From: Amanda Scholes on behalf of Planning.Responses
Sent: 25 April 2019 08:50
To: Planning Scanning
Subject: FW: Planning Application for 2no. additional dwellings to 6 Manor Road, Rustington
Attachments: Side Elevation_A4_scale 1_50.pdf; Front Elevation_A4_scale 1_50.pdf

Planning Application No. R/72/19/PL.

Further to our telephone conversation on Monday, 15th April, 2019, in connection with the above application for the two proposed detached chalet bungalows in addition to the existing detached bungalow on the site, we wish to raise an objection to the current scheme and give our concerns regarding the size, heights and positioning of the proposed chalet bungalows.

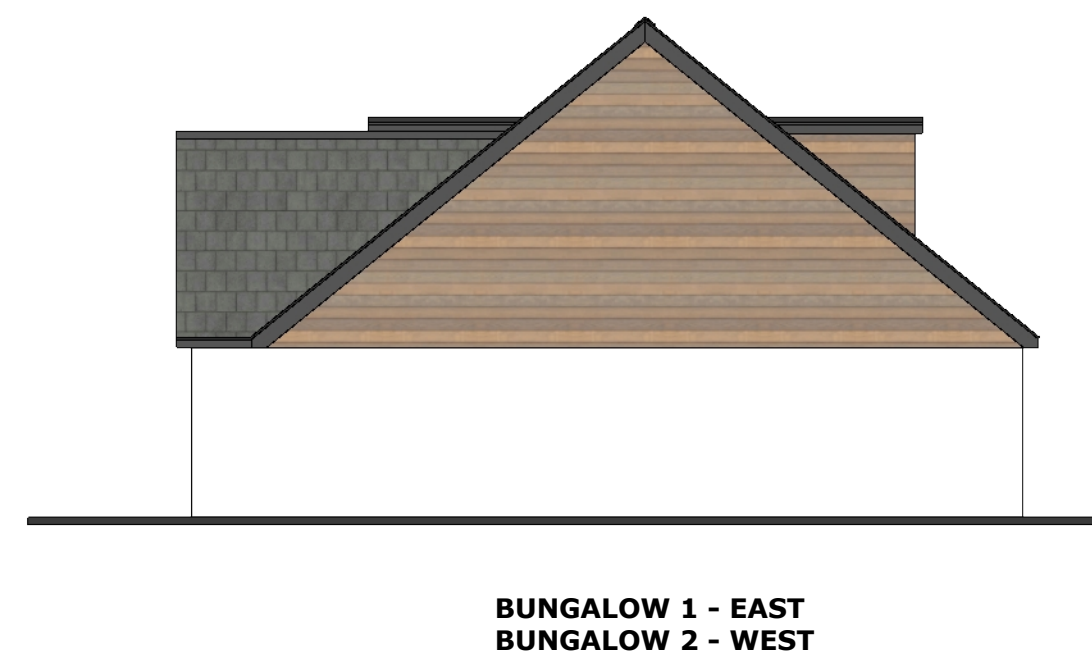
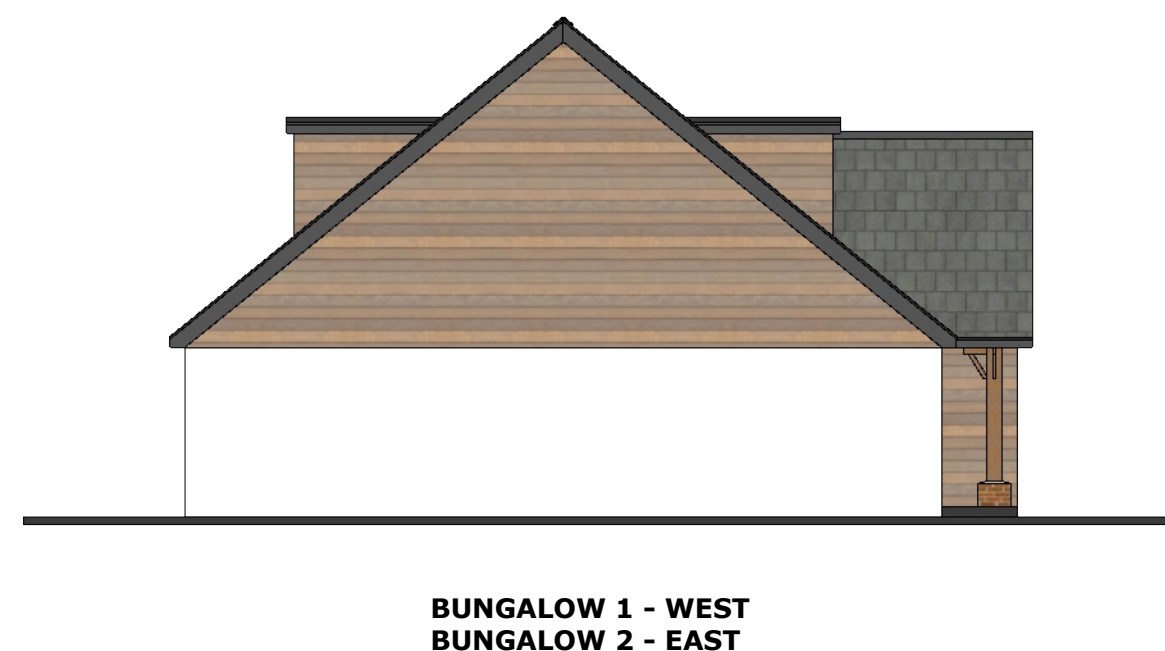
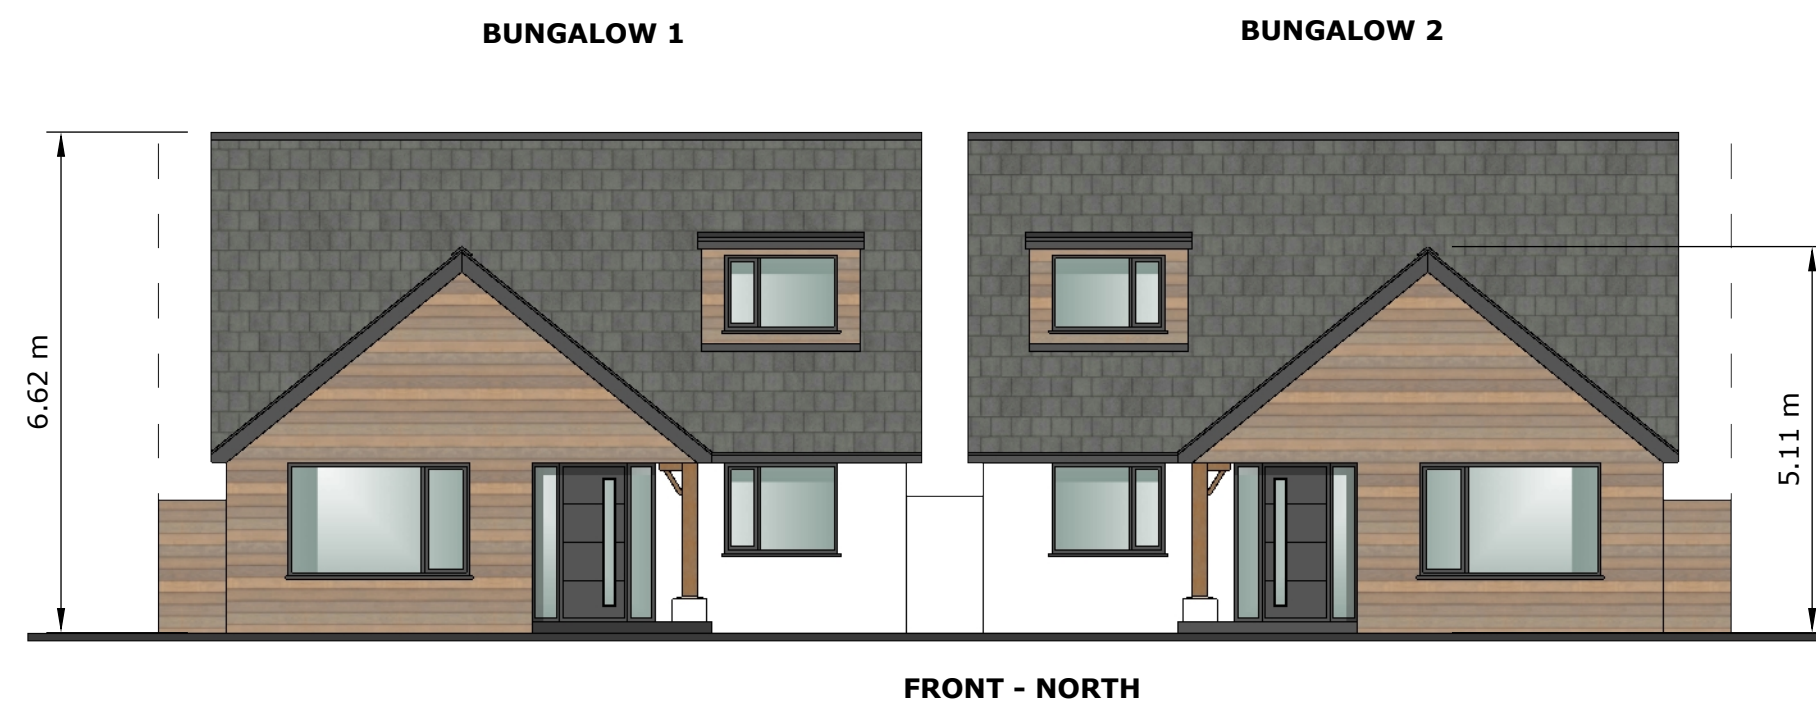
1. The Ridge Height - the design statement states the ridge height will be 6.2m but the elevation drawing show a height of 6.62m and the elevations appear to scale the larger height, a difference of 0.42m.

We would like clarification which is the correct height to be taken.

2. The roof plan on the site drawing does not show the front and back dormers but more importantly shows barn hips at opposite ends of each chalet bungalow, however the elevation drawing shows full height gable ends and no barn hips.

We would like clarification which appearance is correct.

4. On the first floor plan in Bedroom 2 a side window is show, which will overlook our property and Grafton Close, however the elevations fail to show this window.

We would like clarification if this window is proposed or not.

BLOCK PLAN: 6 MANOR ROAD, RUSTINGTON.

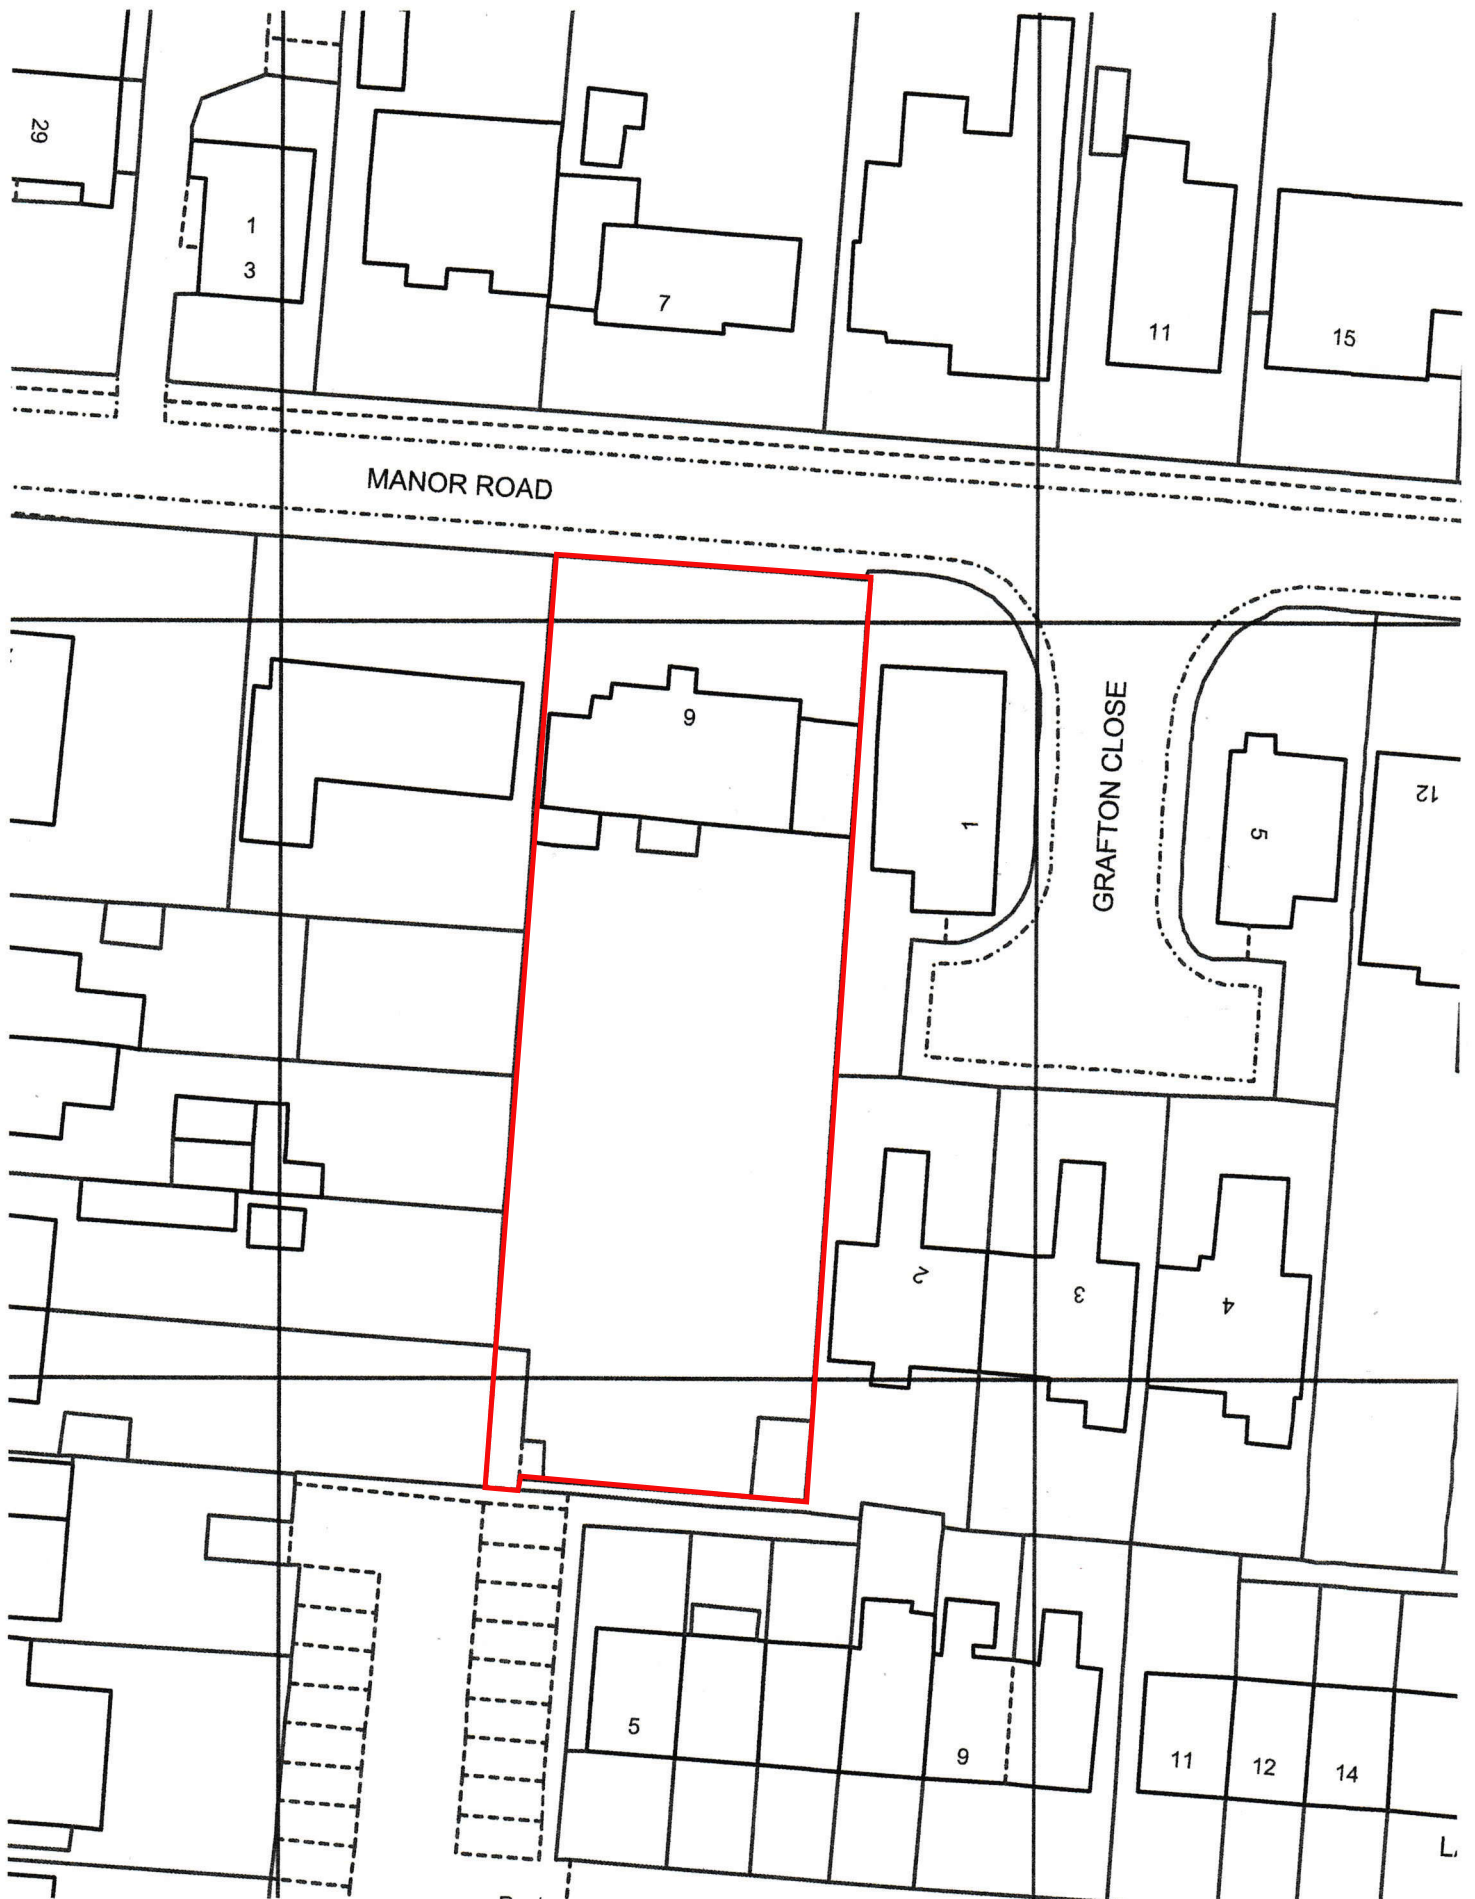
3. The proposed site plan shows a dimension of 1.92m between our property and the nearest chalet bungalow and a figure of 0.9m between the boundary and the new dwelling, which leaves a figure of 1.02m from our property to the boundary. The actual dimension from our property to the centre line of the boundary is 0.87m approx., meaning the distance between our property and the nearest chalet bungalow could at a later date become closer as the two boundary figures of (0.90m and 0.87m) give a reduced figure of 1.77m.

We would like clarification that the figure of 1.92m is the correct measurement to be taken between the buildings and the measurement from the new chalet bungalow to the boundary increased accordingly.
